DRB Application No.: 03-01499 (P&F)
Project Name: LANDS OF ANGIE GALLEGOS
Agent: Michael Gallegos

**CITY OF ALBUQUERQUE
PLANNING DEPARTMENT
Development Review Board
September 17, 2003 Comments**

RE: Lands of Angie M. Gallegos, MRGCD MAP 37, Tract 37A2

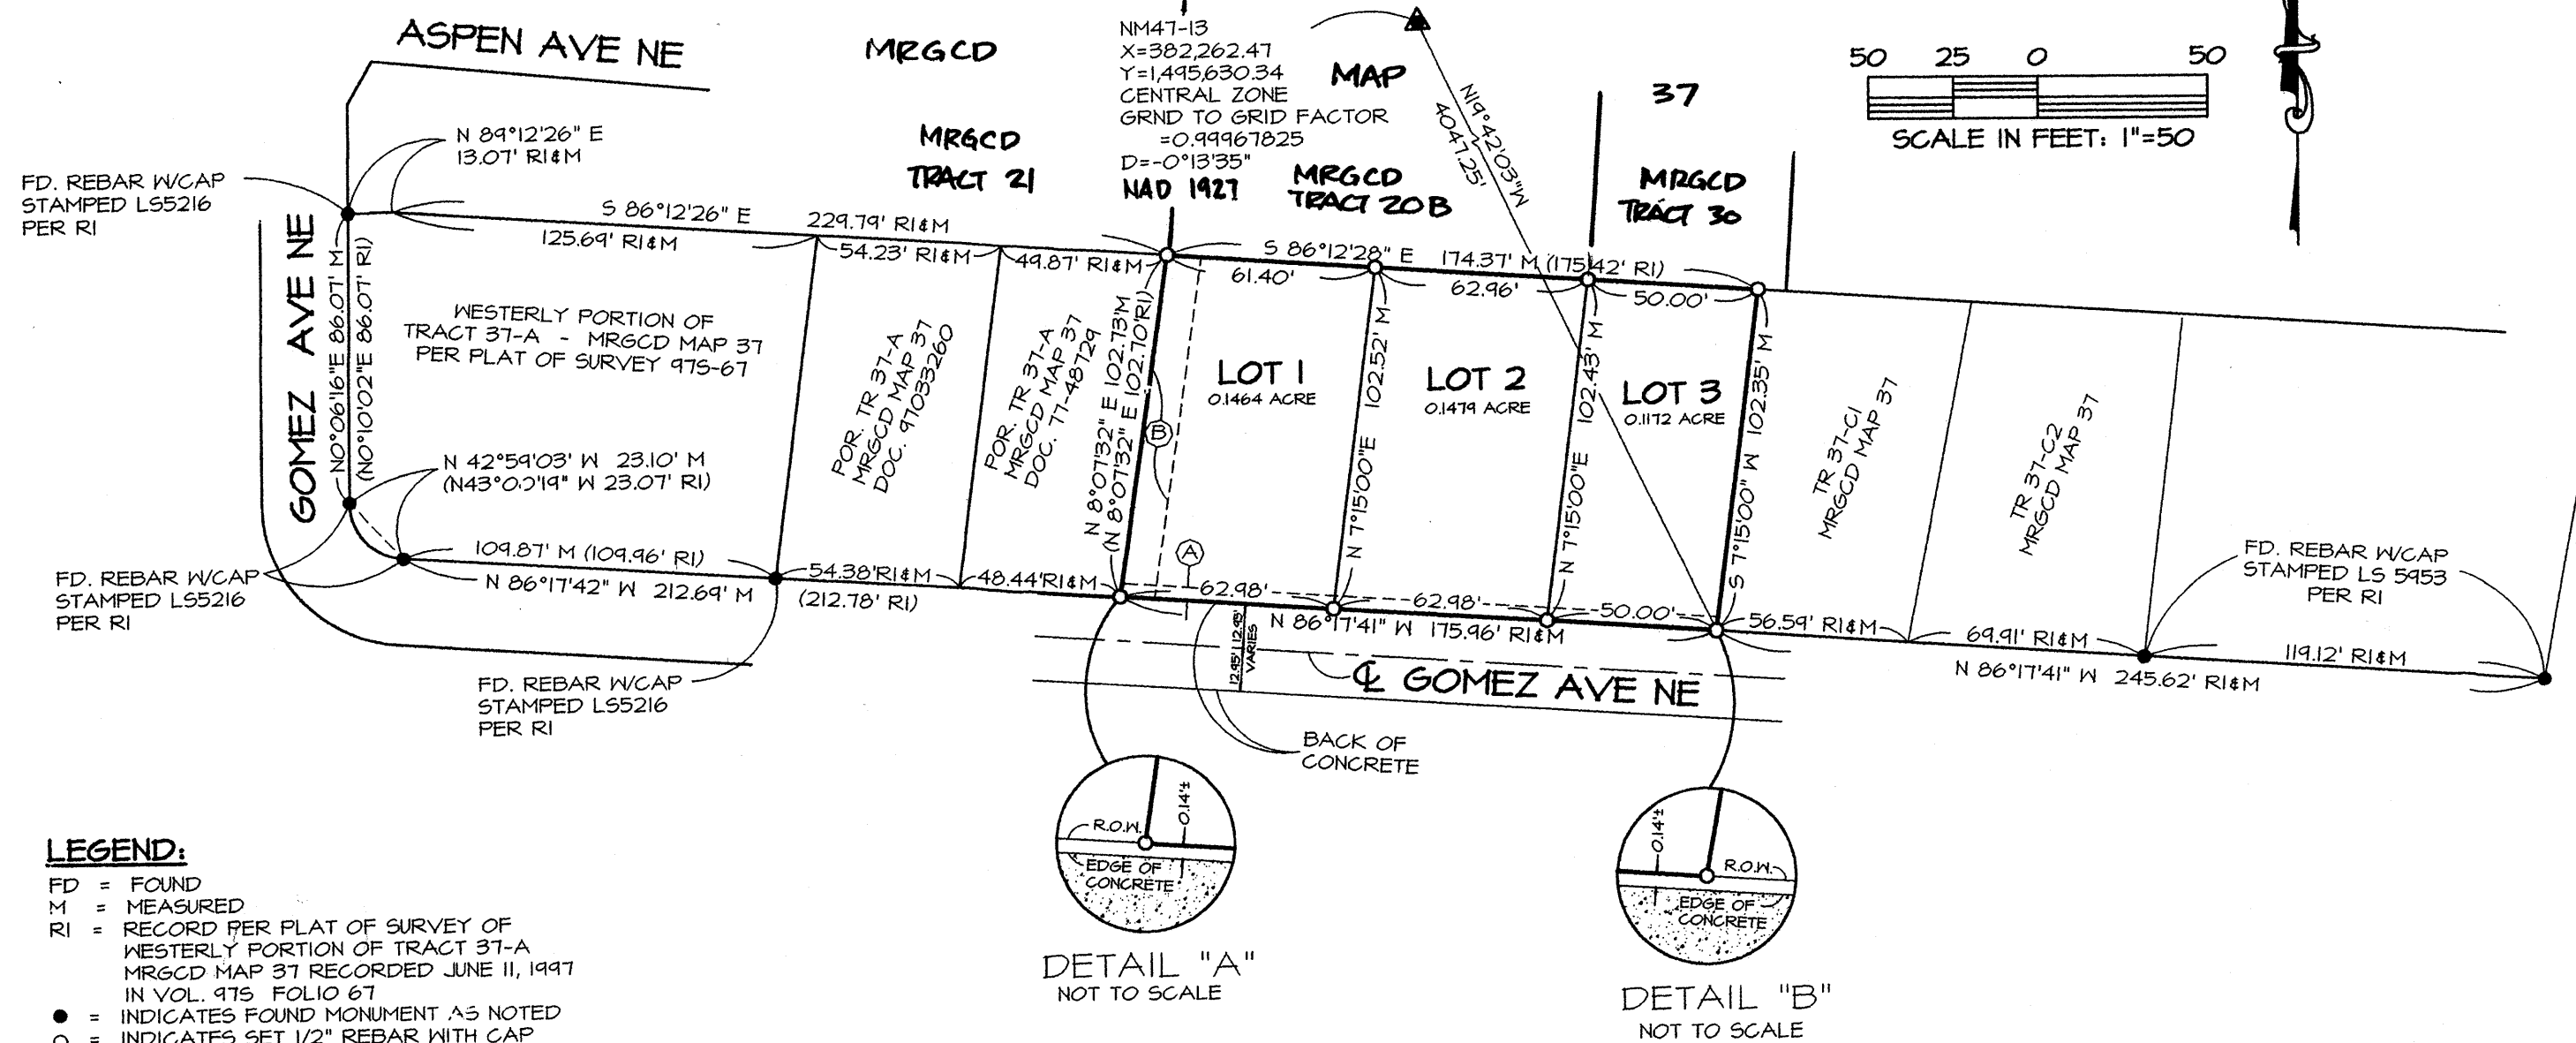
- UTILITIES: Installation of Water Service and Sewer Service must be completed.
- _____
- Review Road Dedication Call-Outs. (NOTE A)
- _____

No objection to the subdivision as shown given the fact that the 2 houses are already existing & the 15' front setback is already existing as well.

No.	Comment
<input type="checkbox"/>	A site sketch is needed showing the pavement, sidewalk, curbing, etc.
